October 10, 2023

Site: 7414 78th Ave SE
Mercer Island, WA 980404
TPN: 2524049075
Area: 68,825 sq. ft. = 1.6 acre

Re: RFI dated August 18th, 2023, changes itemized below, on the report and on the city response matrix highlighted in yellow

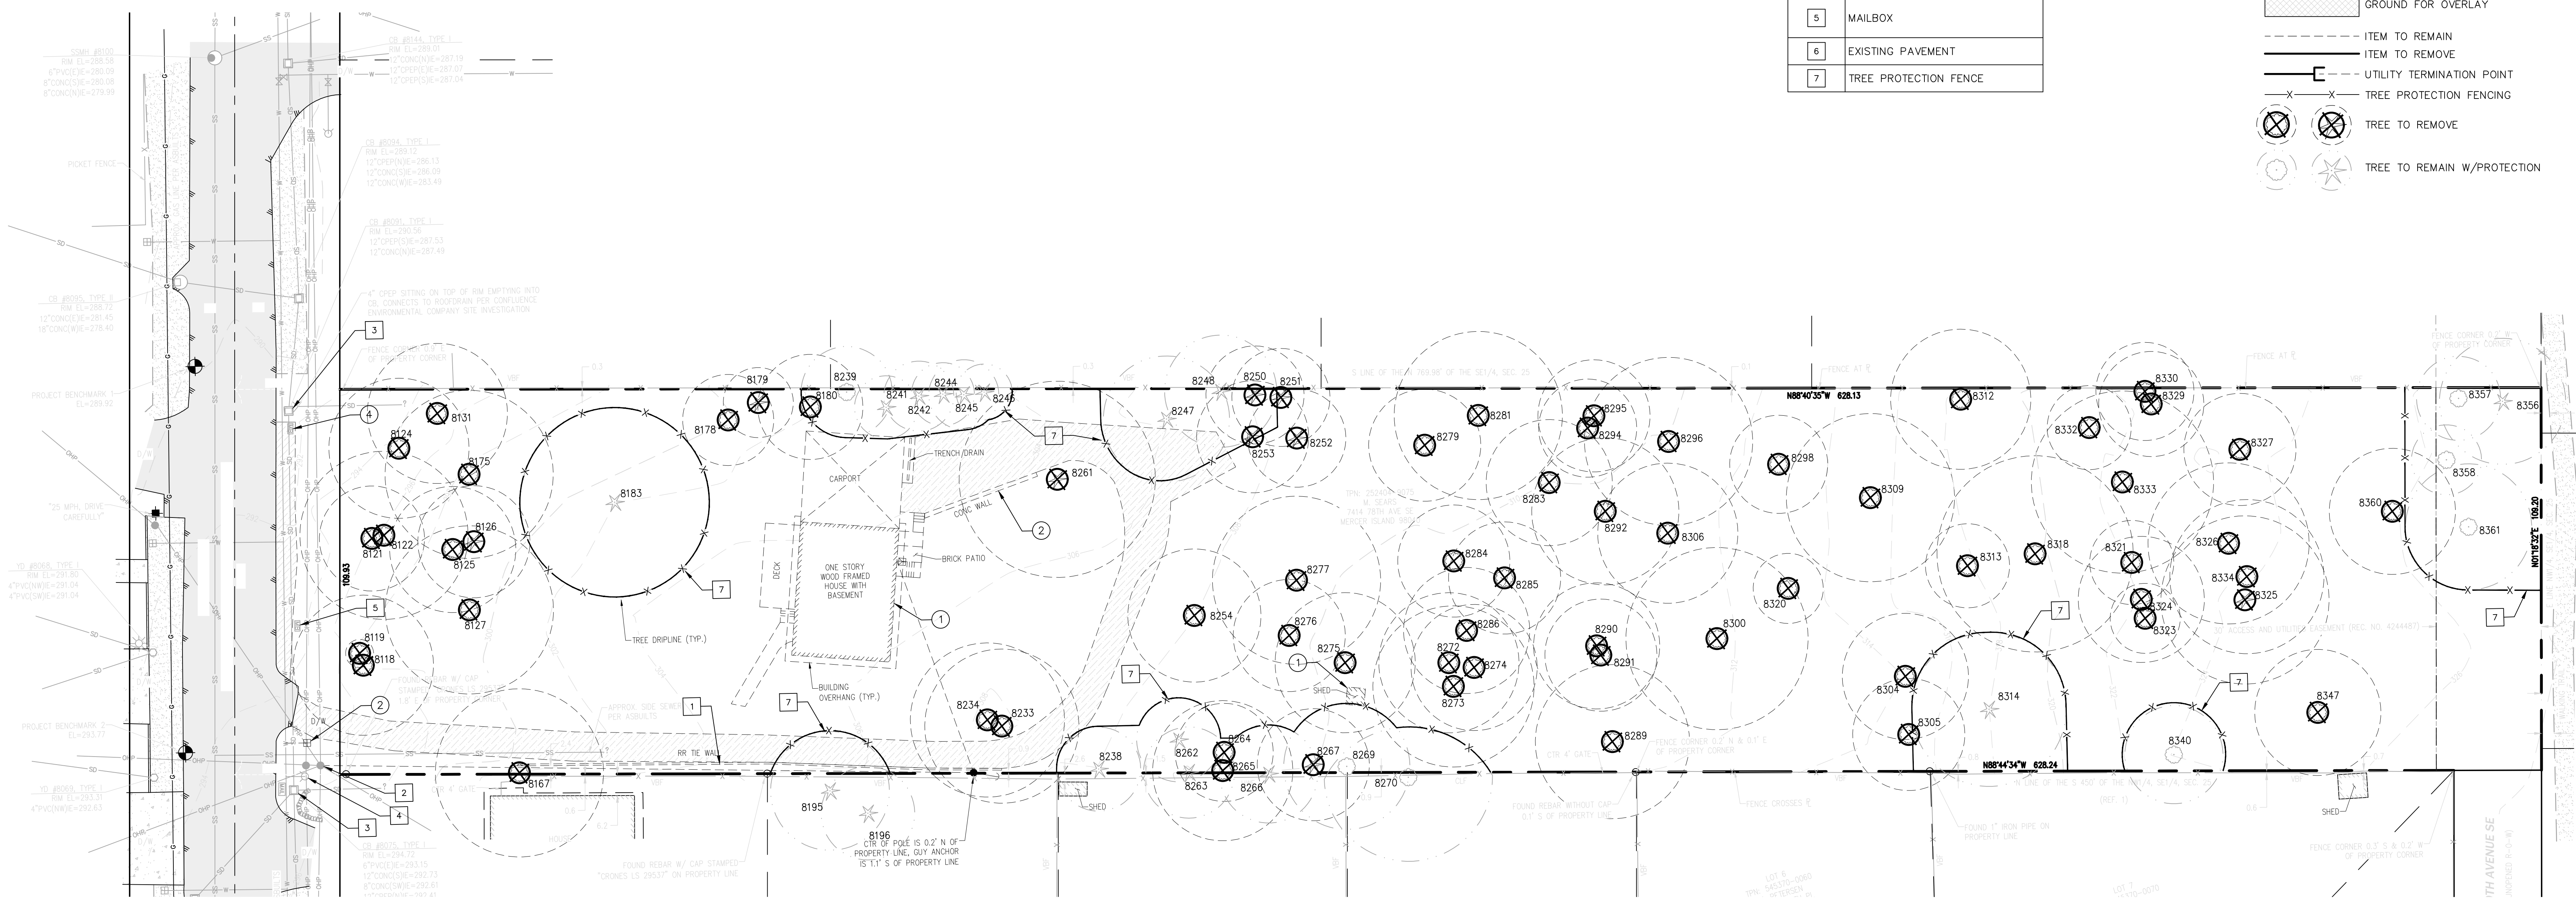
1. The arborist report, tree inventory worksheet, and plan set must all match. The tree table on sheet C1.1 of the plans must be updated to indicate which trees are exceptional by grove status.

I added an additional column to identify whether a tree was in a grove, as well which grove 1-3
